Re: Subdivision Exemption Request – EA1898  
Rock Creek Canyon – Snell Parcel Acquisition

### RESPONSE TO REVIEW BY EPC

CHEYENNE MOUNTAIN STATE PARK EXPANSION - ROCK CREEK CANYON PARCEL
EXEMPTION PLAT
CITY OF COLORADO SPRINGS

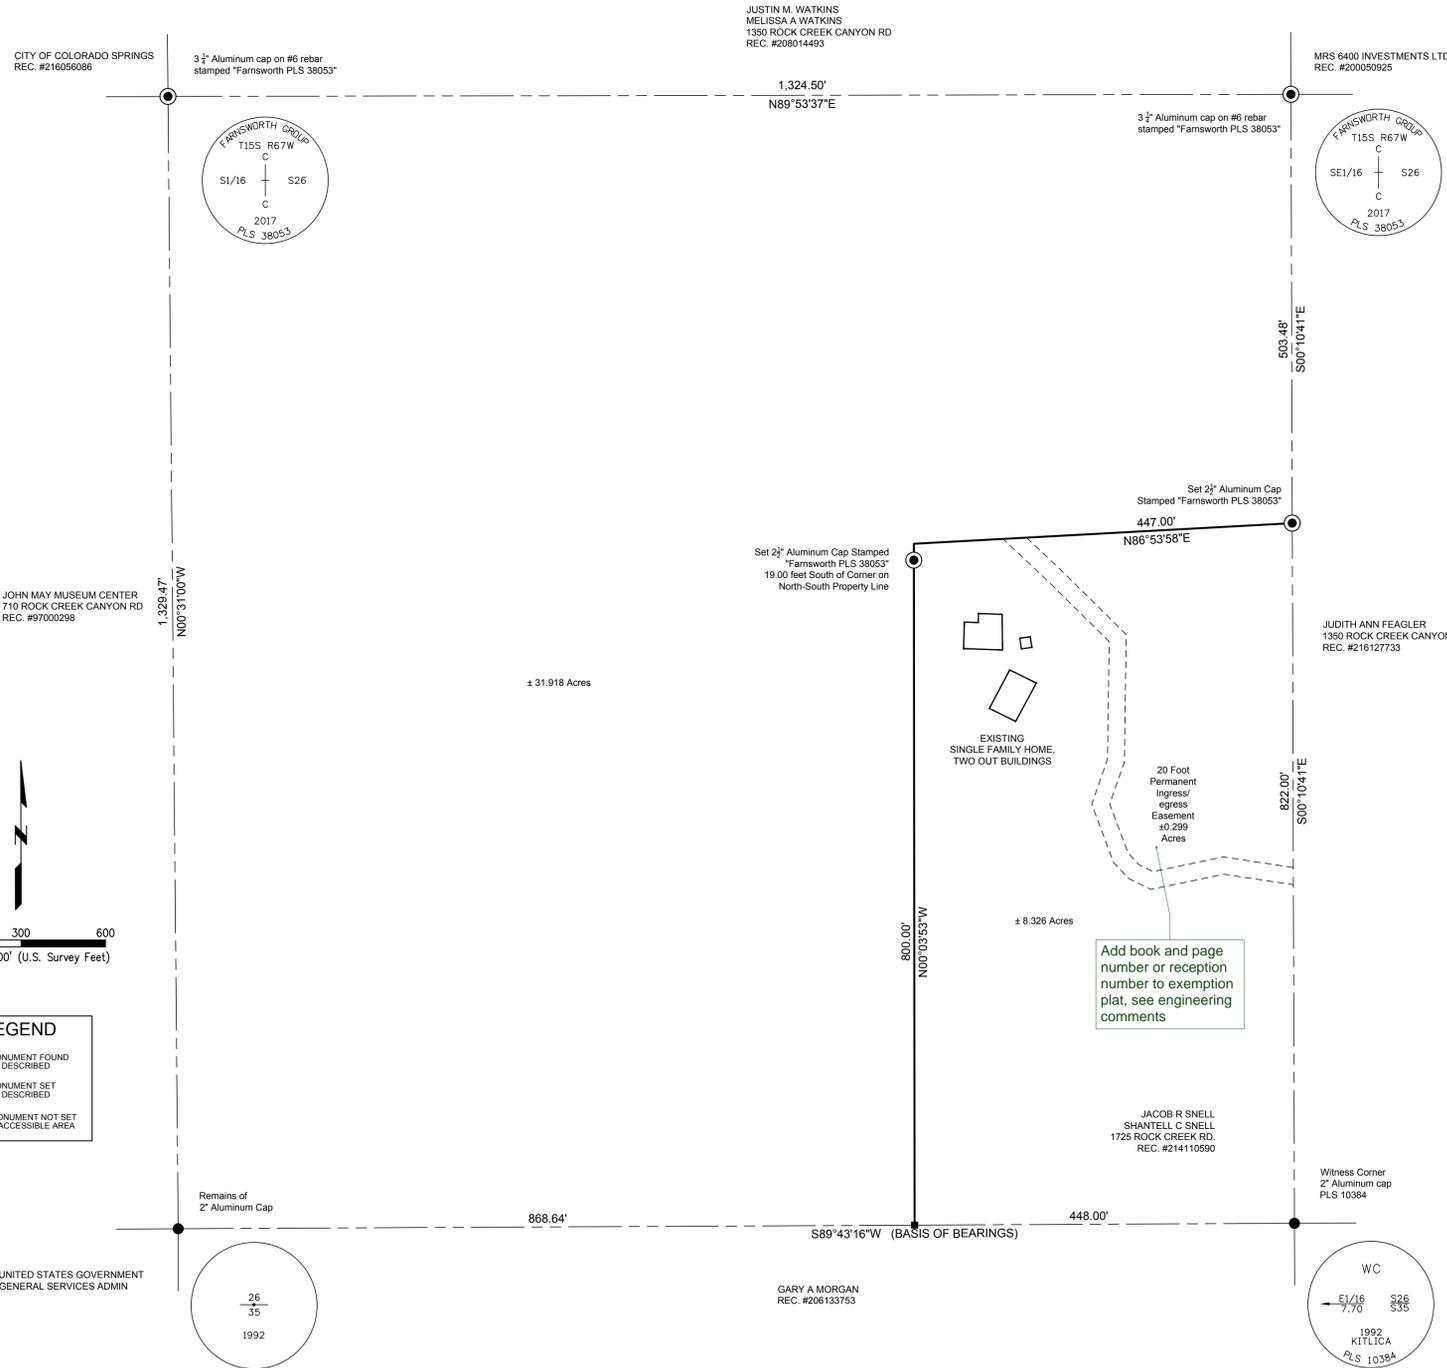
- See Redlines concerning application an plat exemption  
*Response: The Application Form has been revised with the owner information corrected).*
- See Redlines concerning application an plat exemption  
*Response: The Exemption Plat has been revised according to the redlines provided by El Paso County "EPC".*

- Please consider naming to something more particular to the area the open space is located.  
*Response: The title has been updated*
- Provide documentation showing an ingress/egress easement to the nearest public road.

- If you are wanting to record the plat it will require the changes to the signature blocks, if you are wanting to deposit only, then the changes to the title and the engineer comments need to be addressed, and the county signature blocks can be removed. You can speak to the surveyor about the deposit process.

Engineering comments have been provided on the following documents, which will be uploaded by the project manager: -Subdivision Exemption Plat

I have one question per the plat that you submitted and the comment came for are Land Base Service group if you need to clarify please contact Rick Brewster at 719-668-8334 thanks Al 1.) In the title of the plat its not the City Of Colorado Springs and that would need to be changed.

*Response: The City of Colorado Springs is seeking to deposit the plat only. Applicable changes as requested have been made to accommodate the deposit.*

*Response: The Exemption Plat has been revised according to the redlines provided by EPC.*

*Response: The Exemption Plat title has been revised*
